**CITY OF ALBUQUERQUE  
PLANNING DEPARTMENT  
December 5, 2012  
DRB Comments**

**PROJECT # 1009321**

**APPLICATION # 12-70367**

**RE: Tract A, Ainsworth Tract**

**PLAT OF
TRACT A-1 AND A-2
AINSWORTH ADDITION**

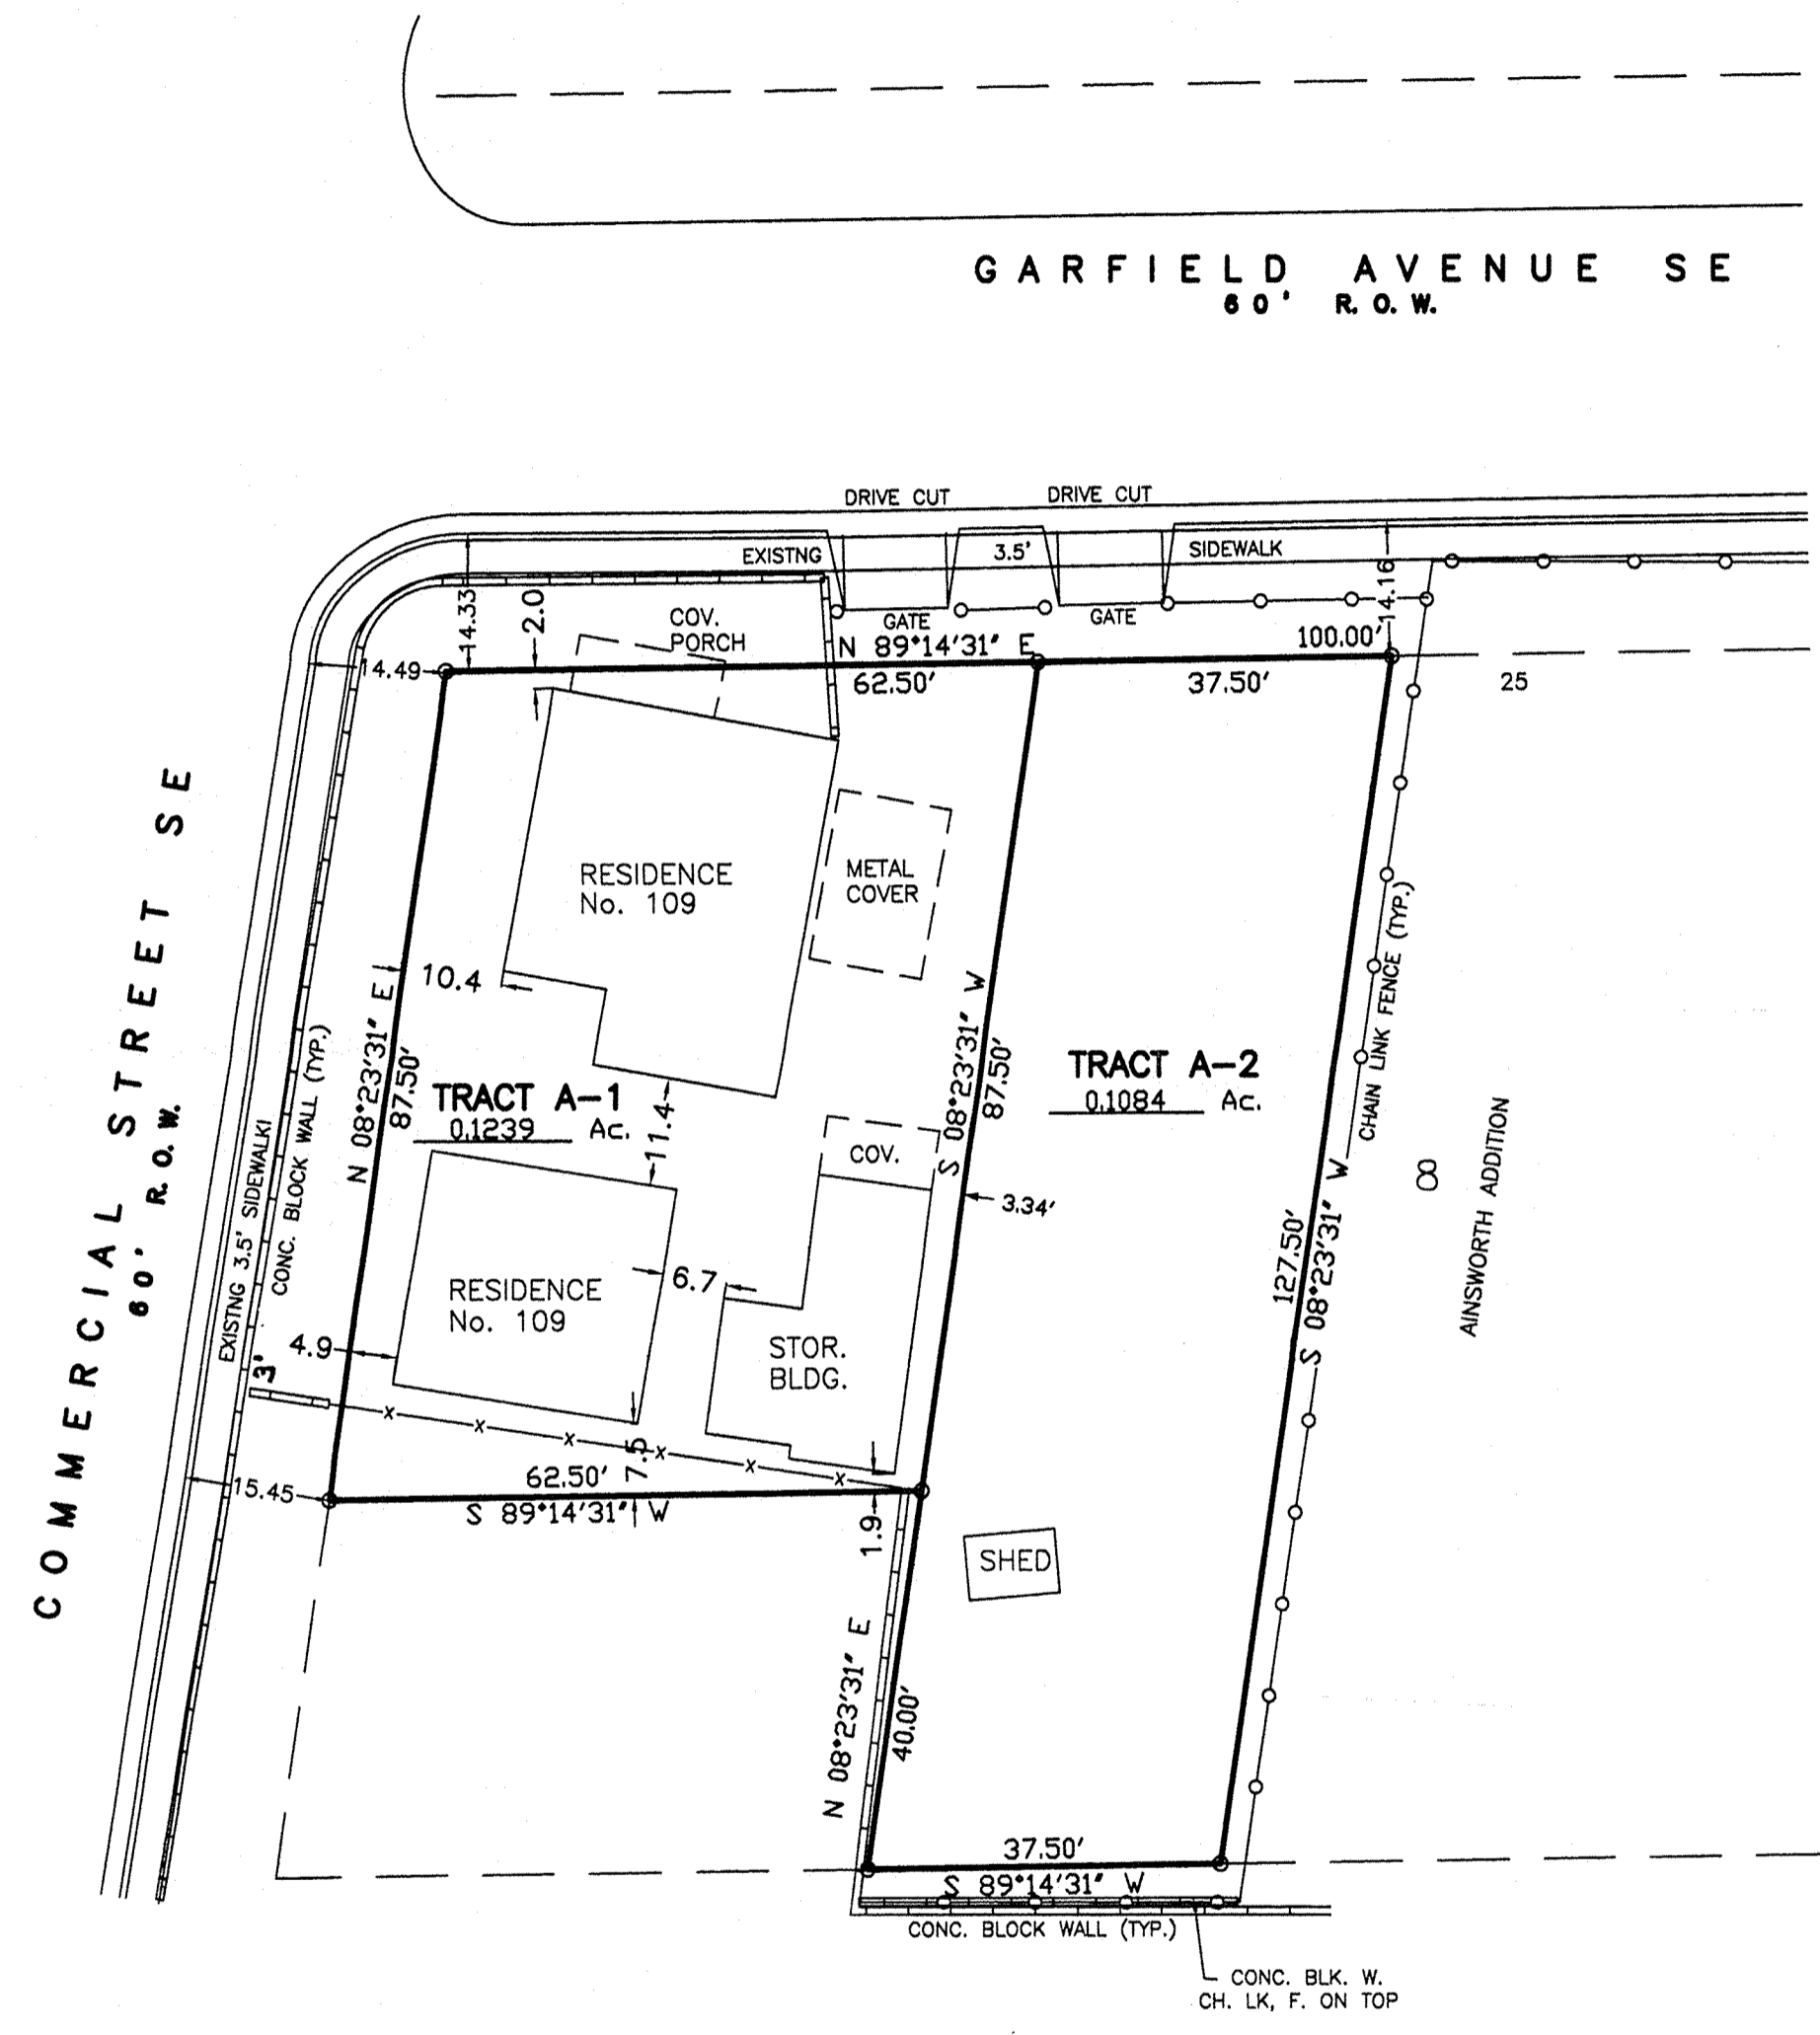
The site is zoned MR per the South Broadway Sector Development Plan, which corresponds to the R-1 district of the Zoning Code – please provide a corrected Notice of Decision for approval of variance to minimum 5,000 sq ft lot area (submitted Notices both reference approval of lot width variance) and reference lot area variance on the plat.
